NORTH FALLS OFFSHORE WIND FARM

**Appendix M5 to the Natural England Deadline 5 Submission**  
**Natural England's comments on the Examining Authority's 2<sup>nd</sup> Written**  
**Questions on the North Falls OWF application [PD-012 & PD-013]**

Planning Inspectorate Reference EN010119

30 May 2025

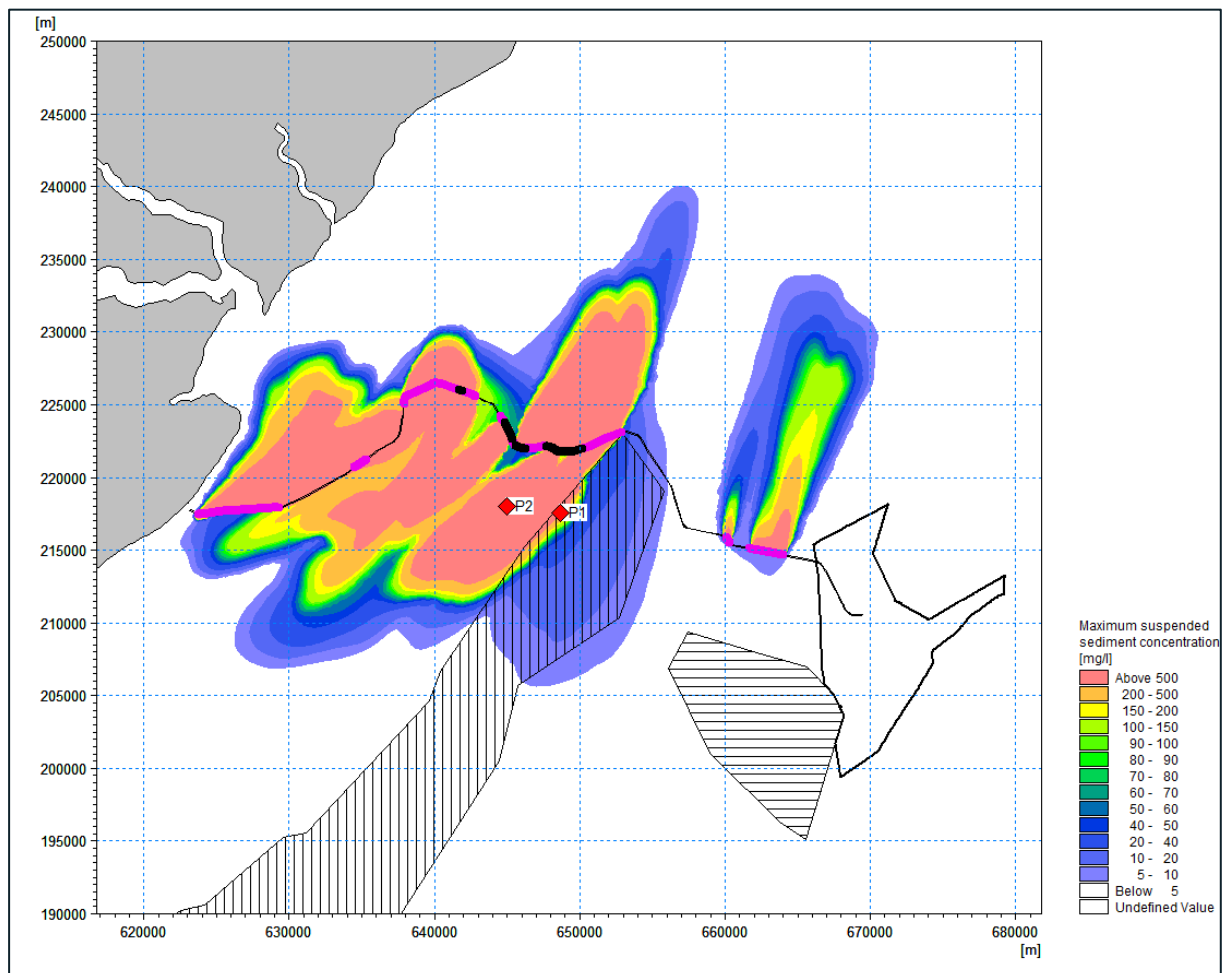
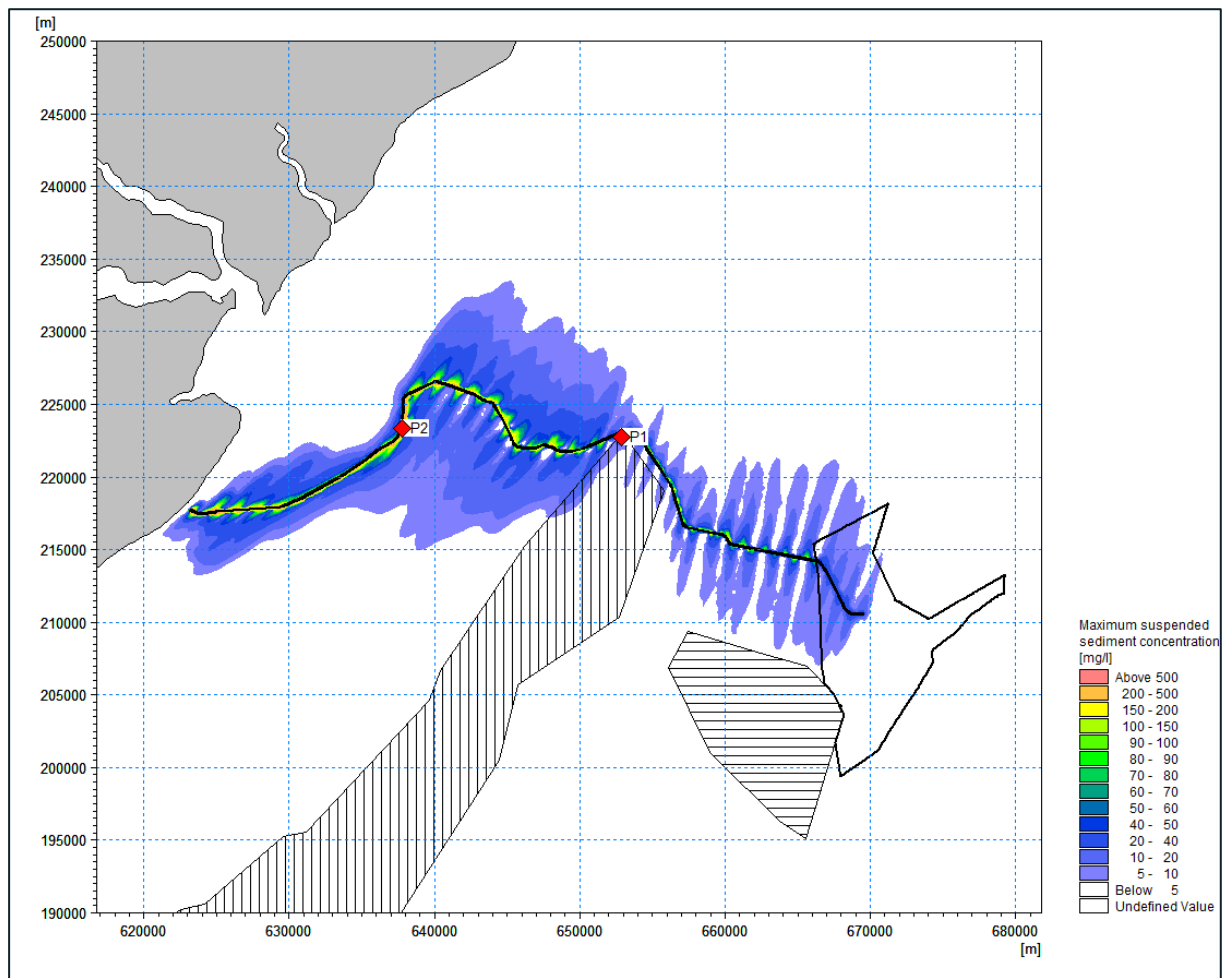
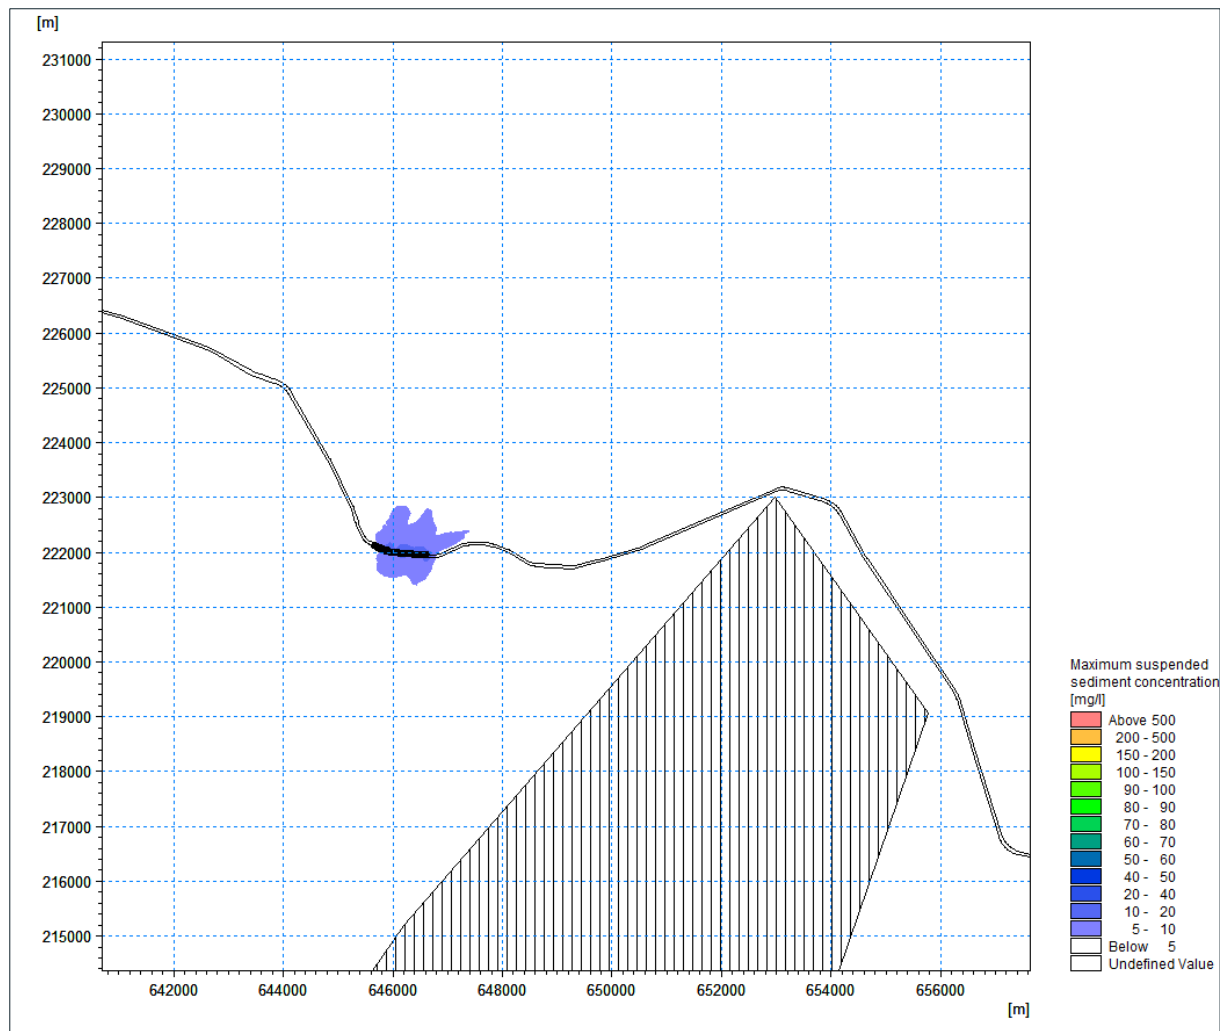
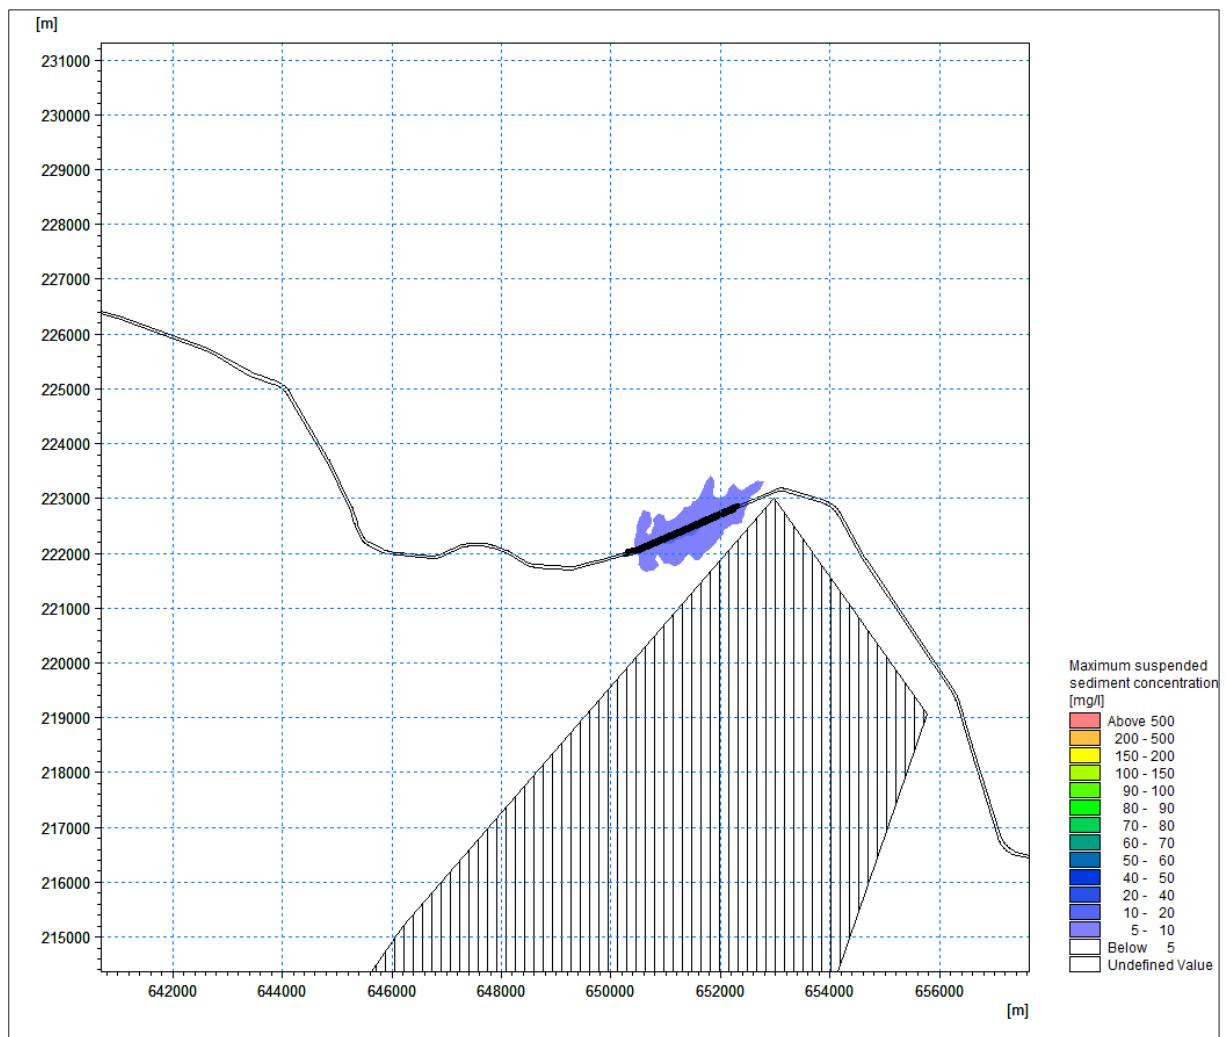
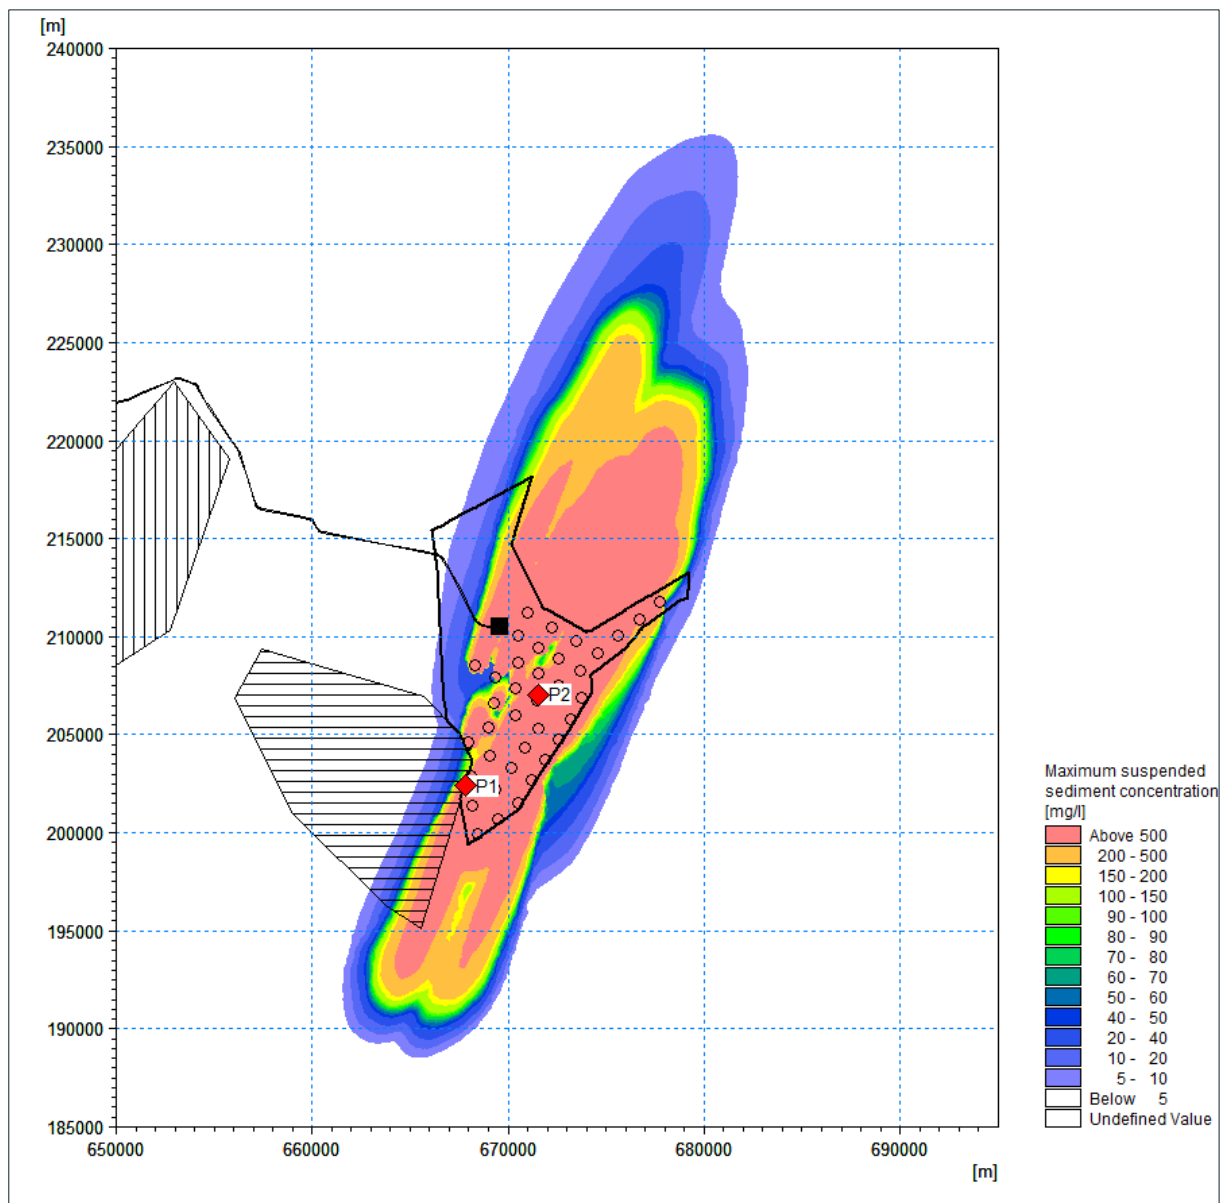
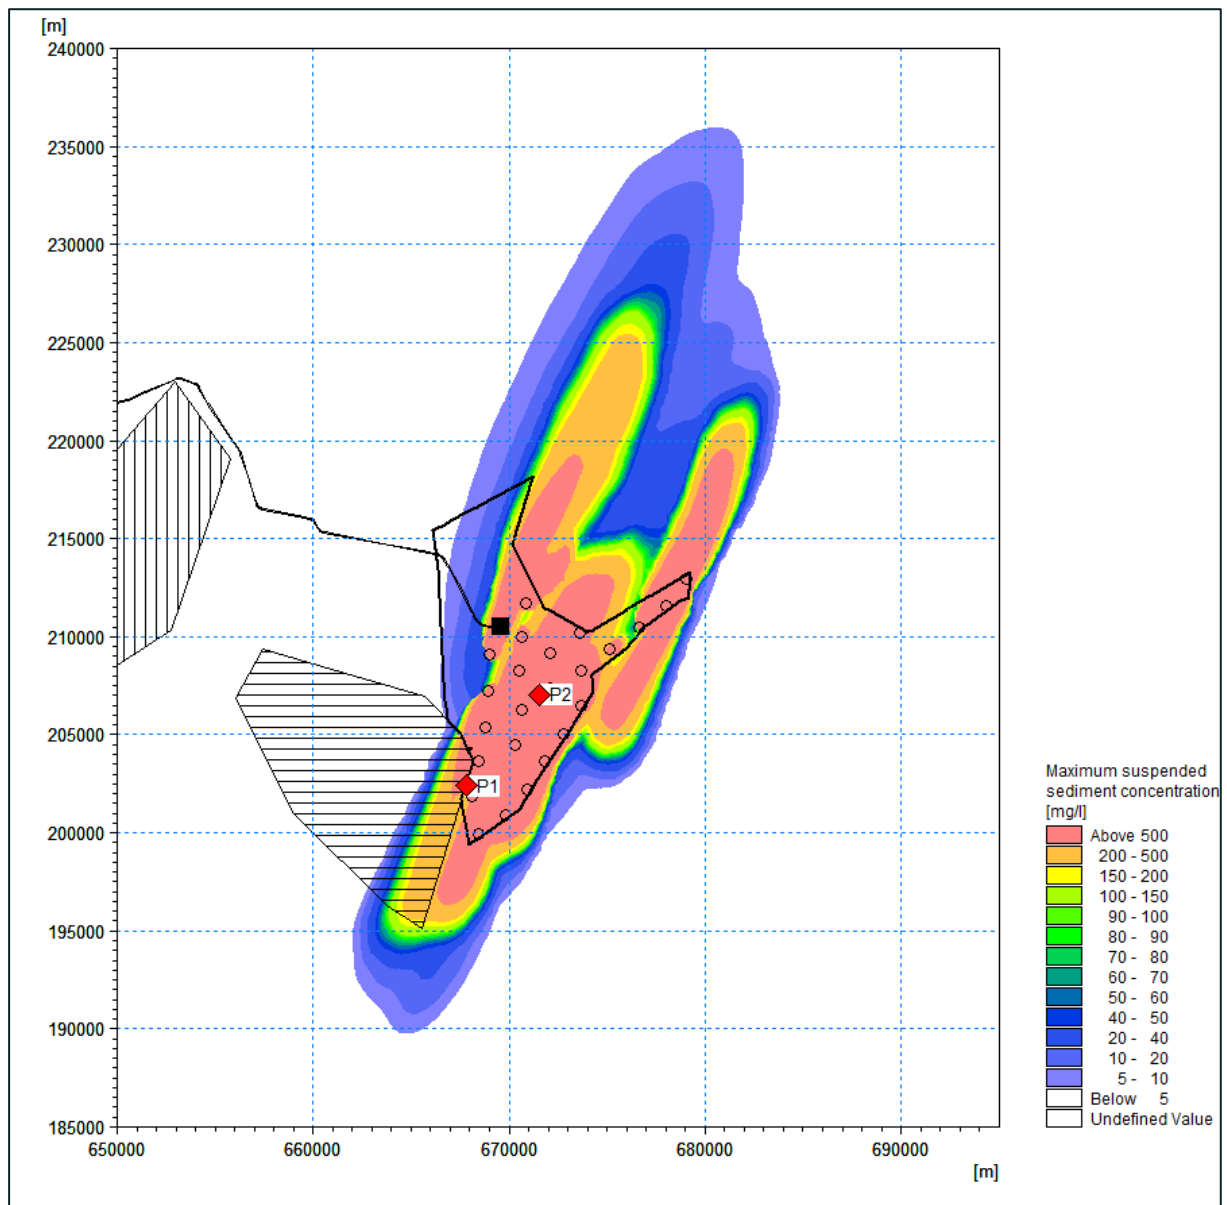
| ExQ2 | Question to: | Question:   | Natural England's response:   |
|------|--------------|---|---|
|      |              | <p>(i) NE – The applicant has submitted updated hydrodynamic and dispersion modelling [REP4-040] [REP4-042] and information about additional offshore mitigation with a view to addressing your outstanding concerns regarding effects from sediment deposition and seabed level change, which have implications for habitats regulations assessment (Margate and Long Sands (MLS) SAC) and marine conservation zone assessment (Kentish Knock East (KKE) MCZ). The ExA requests a detailed response on the additional information at DL5. In doing so, confirm your advice on AEol for MLS SAC and hindrance of the conservation objectives for KKE MCZ. If you consider that AEol and/or hindrance of conservation objectives cannot be excluded, set out what specific additional information you consider is needed and indicate your view as to whether it is likely this can be resolved prior to close of examination.</p> <p>(ii) Applicant – NE's latest Risk and Issues Log [REP4-067] indicates that it is still not able to advice that AEol can be excluded for MLS SAC, or hindrance of the conservation objectives of KKE MCZ. Confirm if any consideration has been given to preparation of a without prejudice derogations case for the MLS SAC, or Stage 2 assessment for</p> | <p>sediment deposition and seabed level change provided by the Applicant at Deadline 4. With regards to our benthic ecology advice, we consider that the Worst Case Scenario for secondary impacts need to be identified, quantified and evaluated sufficiently within an ecological context to provide full transparency in the Applicant's assessment conclusions in relation to impacts within Margate and Long Sands SAC and Kentish Knock east MCZ. An AEol for MLS SAC and hindrance of the conservation objectives for KKE MCZ cannot be excluded currently, however Natural England consider it both possible and likely that this matter can be resolved by the close of examination.</p> <p>(iii) Please see Tables 2 and 3 in Appendix C5 to Natural England's Deadline 5 response.</p> <p>(iv) Please see Table 5 in Appendix C5 to Natural England's Deadline 5 Response</p> <p>(v) Please see Tables 2 and 3 in Appendix C5 to Natural England's Deadline 5 response and Table 4 in Appendix B5.</p> <p>(x) Please see Table 2 in Appendix C5 to Natural England's Deadline 5 response and Tables 4-6 in Appendix B5.</p> <p>(xi) Please see Tables 5 and 6 in Appendix C5 to Natural England's Deadline 5 response and Table 4 in Appendix B5.</p> |
